Comments for Planning Application 21/00345/FUL

Application Number: 21/00345/FUL

Address: Wheatsheaf Yard, The Wheatsheaf High Street Oxford OX1 4DF

Proposal: Conversion of first and second floors to create 9no. student rooms, shared kitchen and common area. Formation of 2no. front dormers in association with a loft conversion. Removal of 1no. window to front elevation. Alteration to 1no. window and 1no. door to front elevation. Insertion of 1no. door to front elevation. Provision of bin and cycle stores

Drawing title:  
Proposed Floor Plans

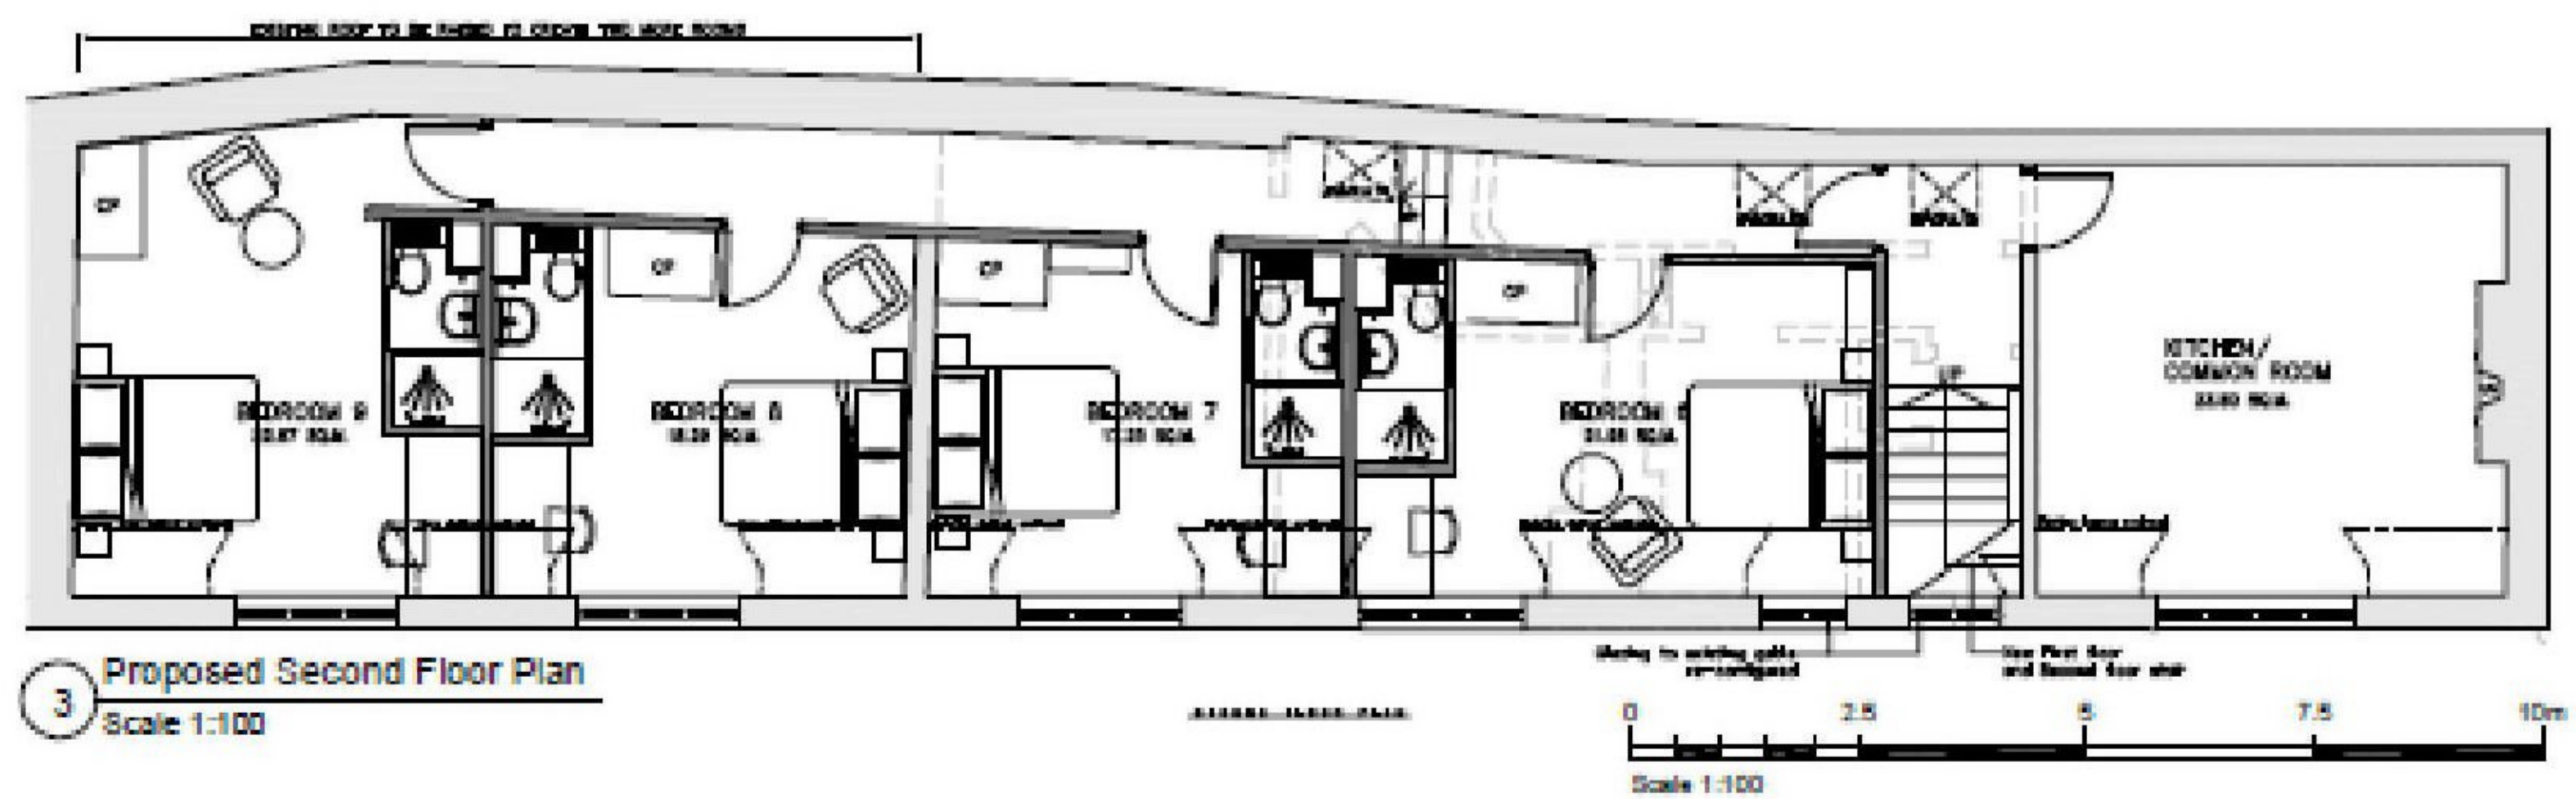
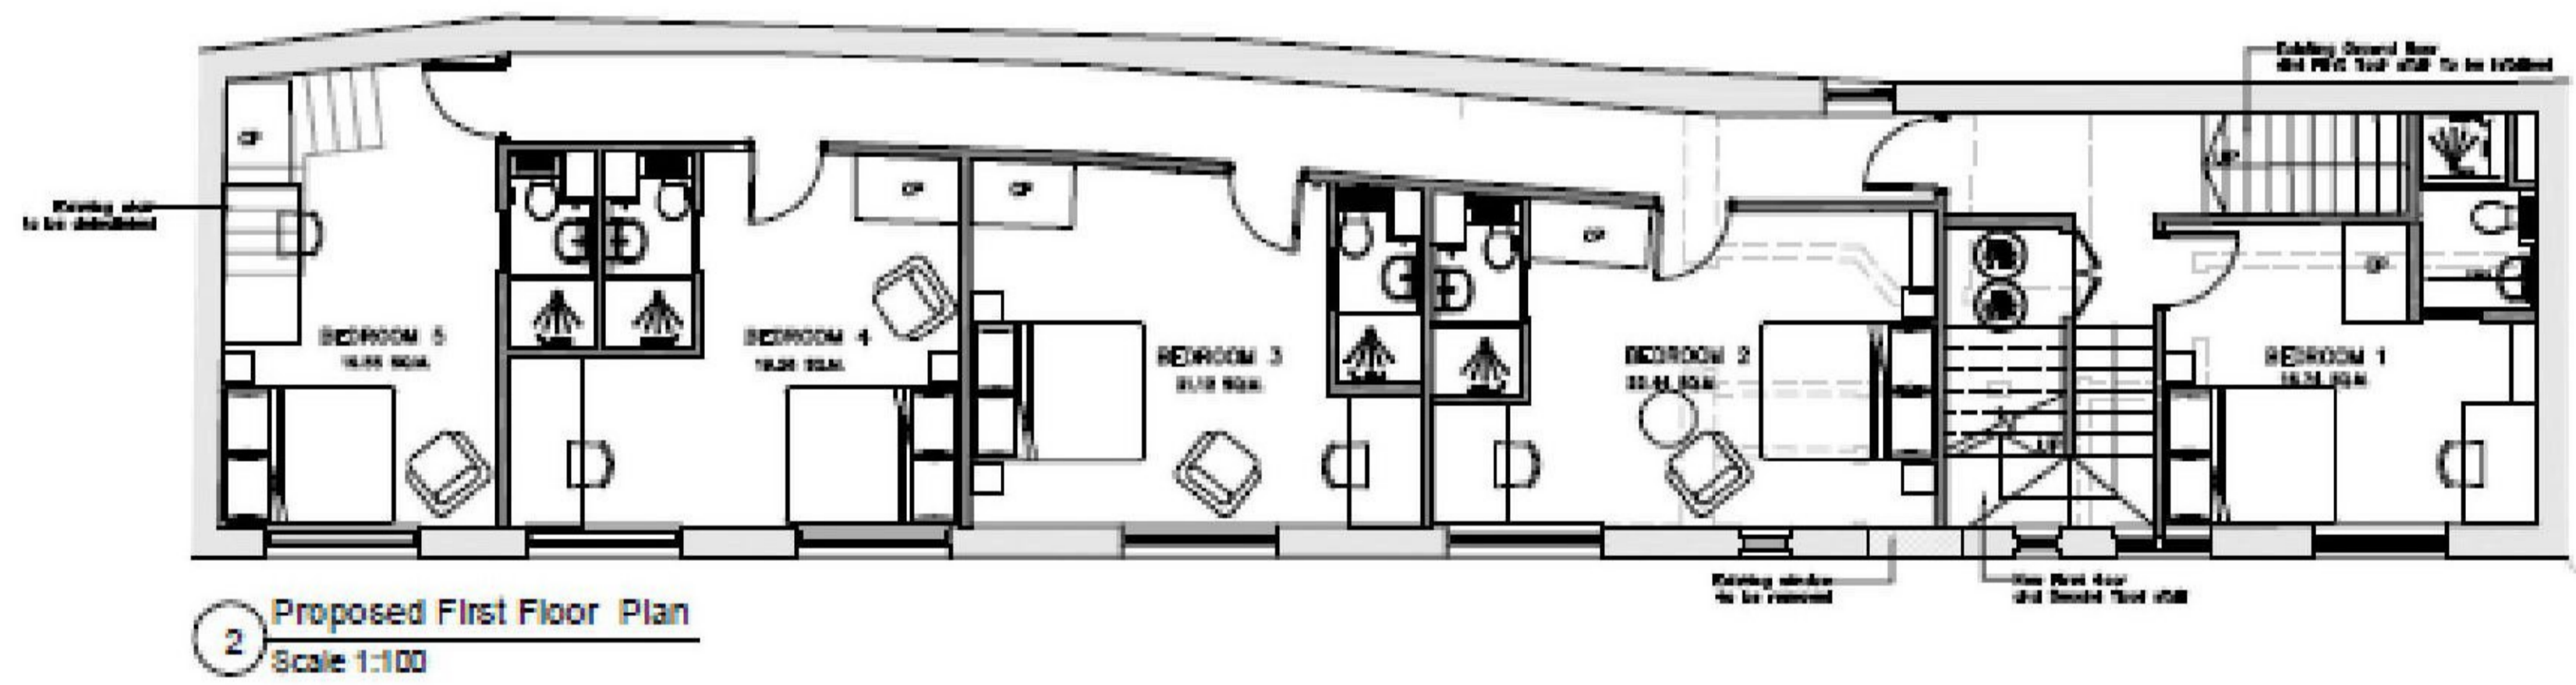
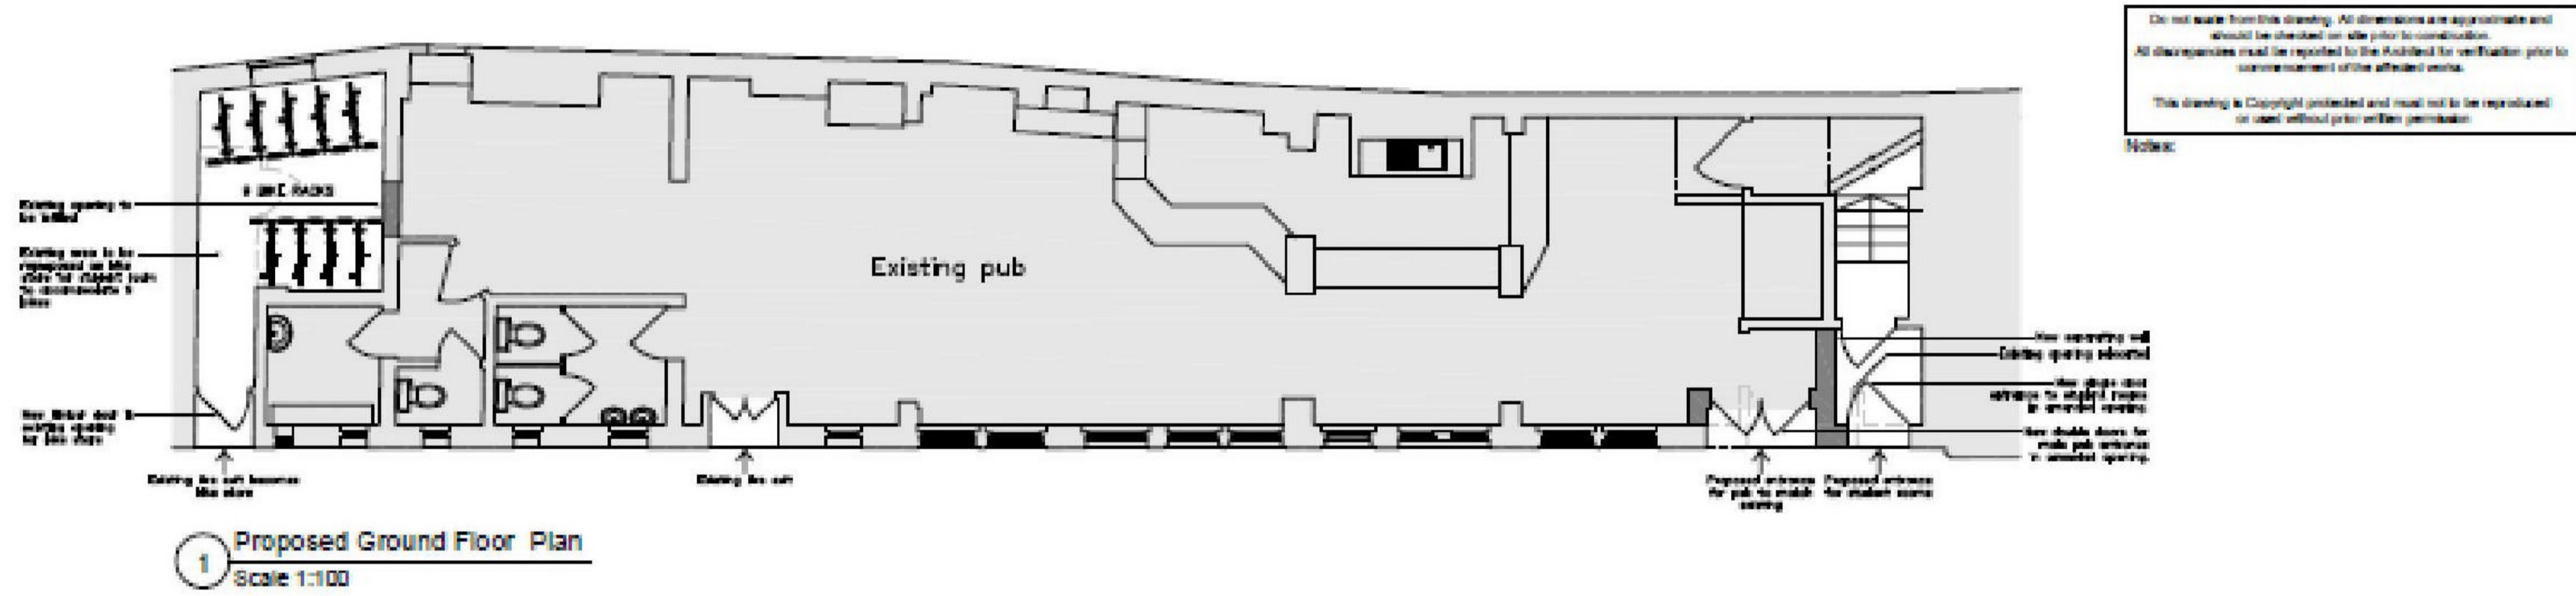
- 2) The drawings submitted with the application are misleading in that they fail to show:-
 - i) internal division walls that will be capable of meeting sound insulation standards

- ii) adequate means of escape in case of fire (one staircase with long "dead leg" travel distance will not meet the Building Regulations). A lack of a route for escape from "escape standard" windows exacerbates this situation.

- iii) adequate standards of daylight and fresh air to the potential residents
- 3) Given the above concerns, the number and layout of the 9 proposed bedrooms are unlikely to be satisfactorily accommodated and this would result therefore in an over-development of the site.

Drawing title  
 Proposed East Elevation

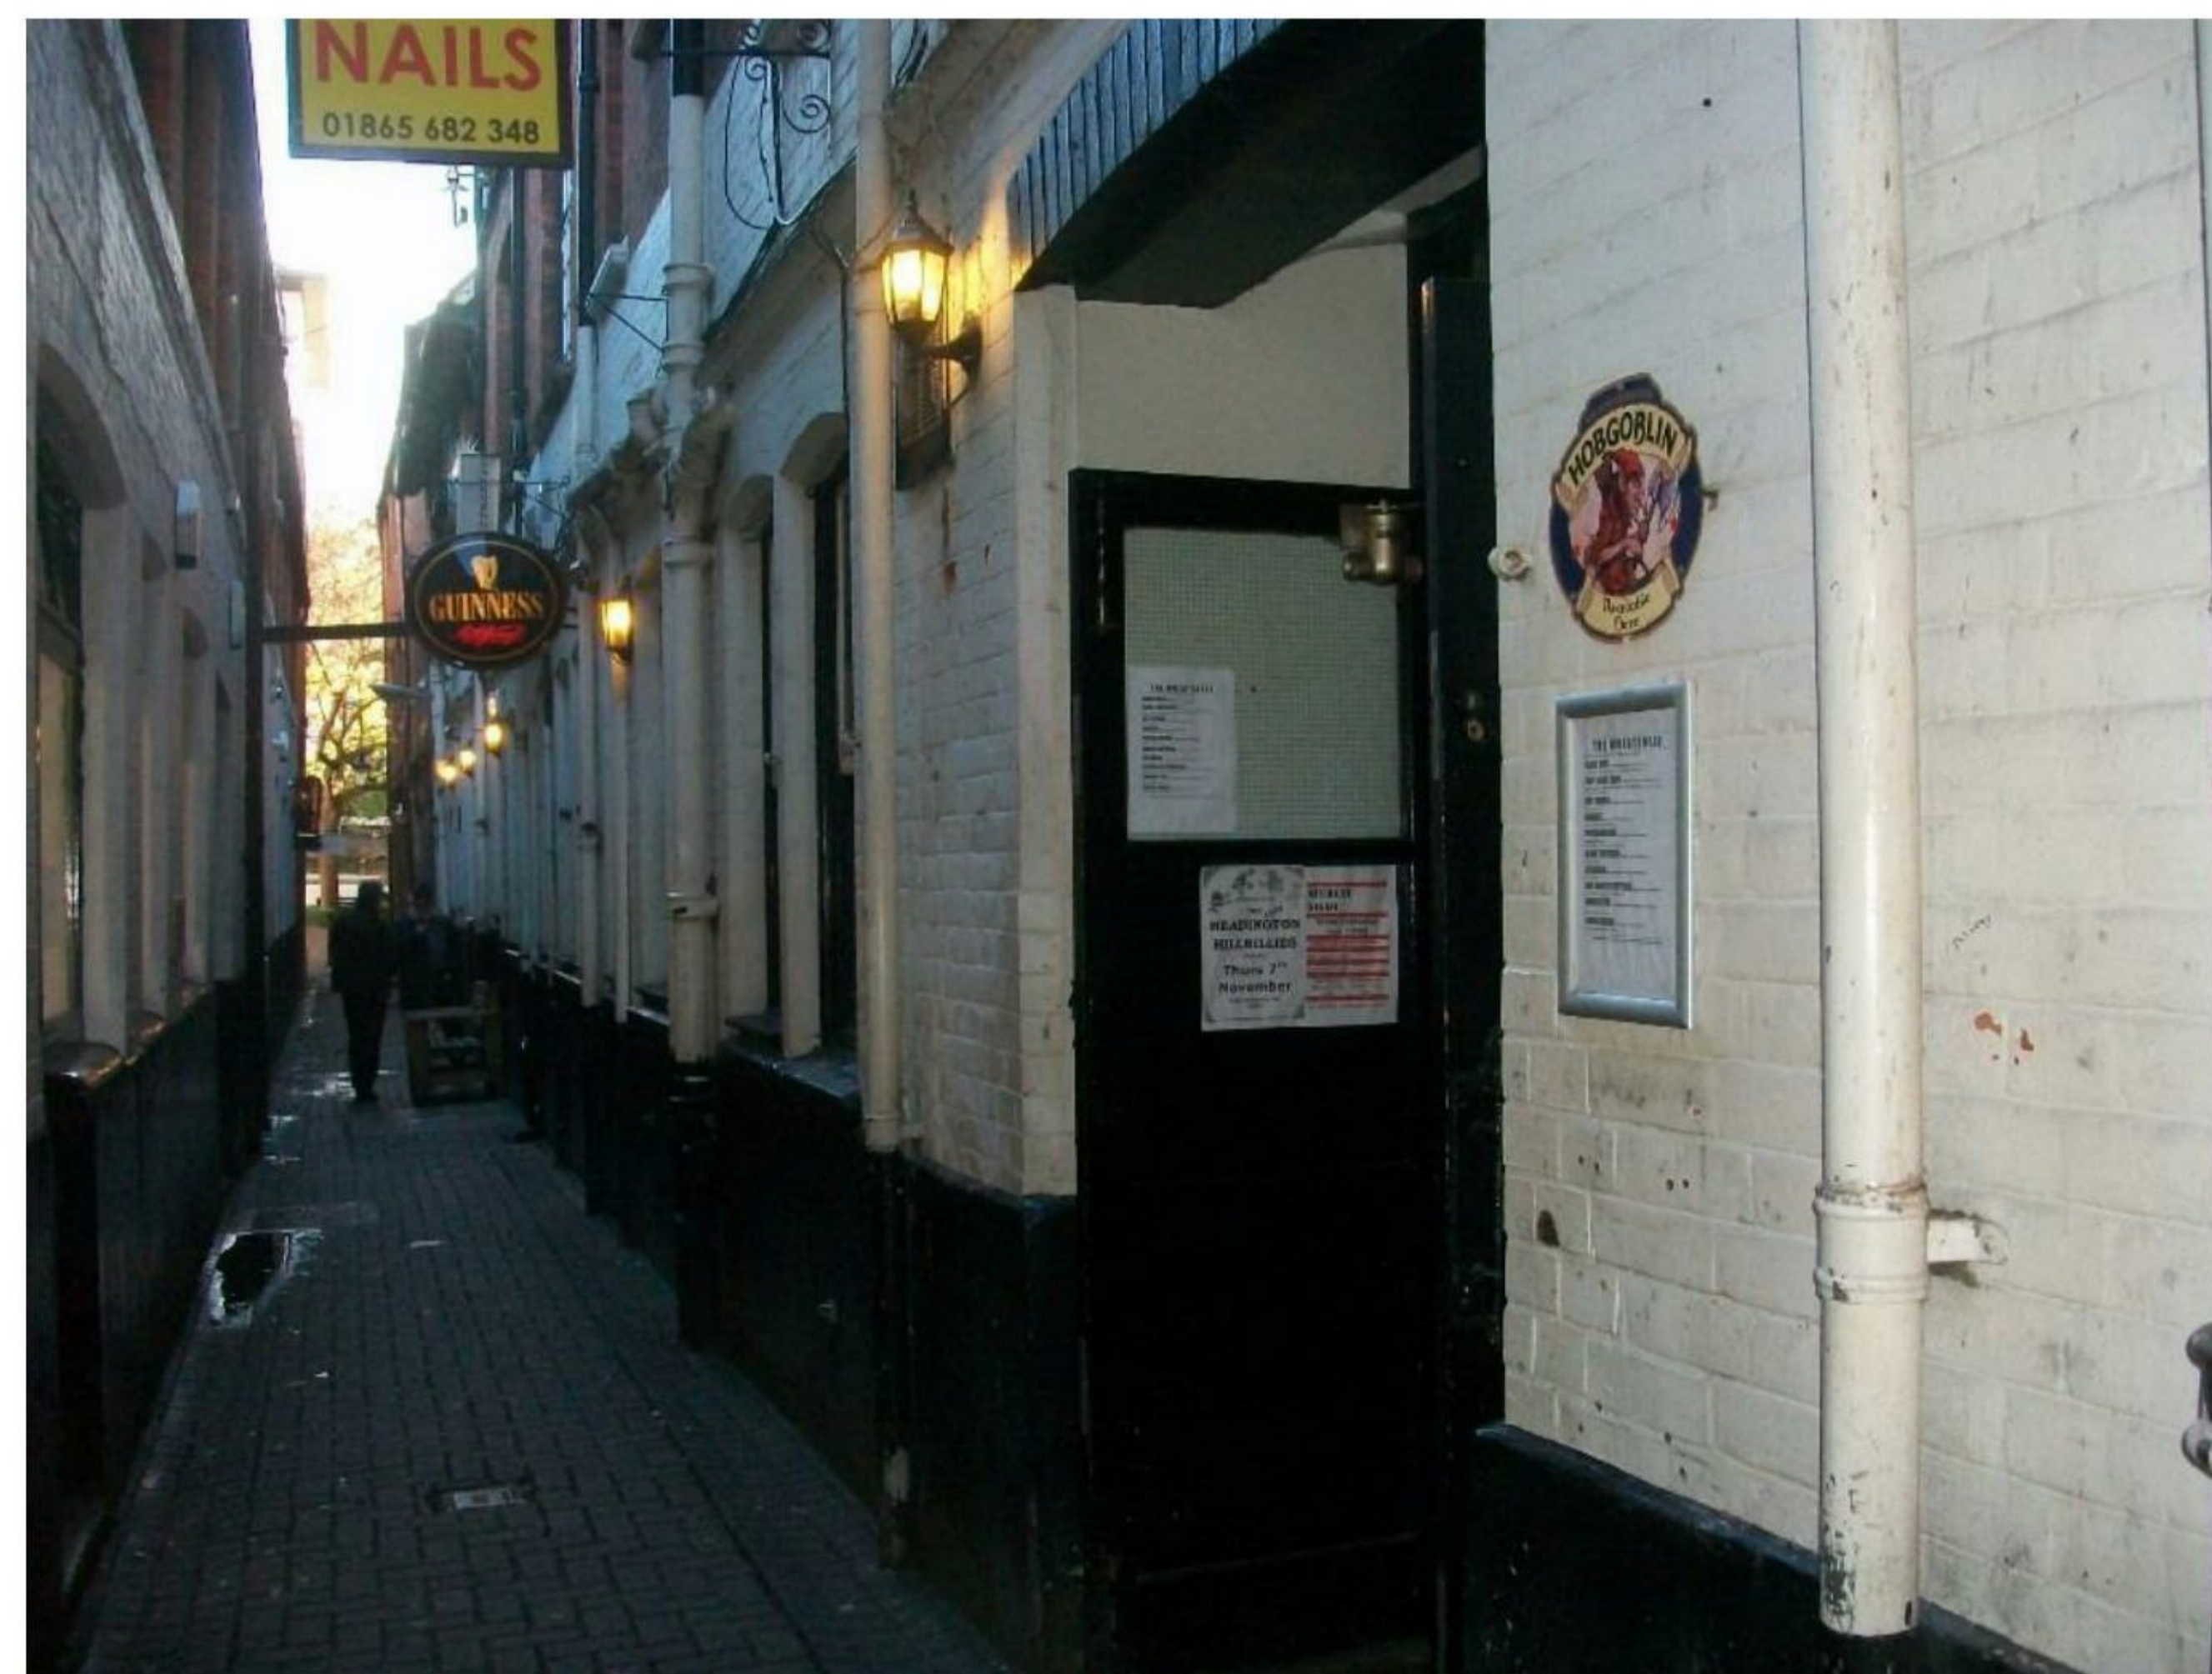
- 1) The raising of the roof to the same level as the adjoining roof shows a lack of respect for the historic fabric, resulting in a "pastiche" of the character of the building. This would have a deleterious effect of the roofscape on this important and historic part of the town (see University Conservation Area Character Appraisal 2018)
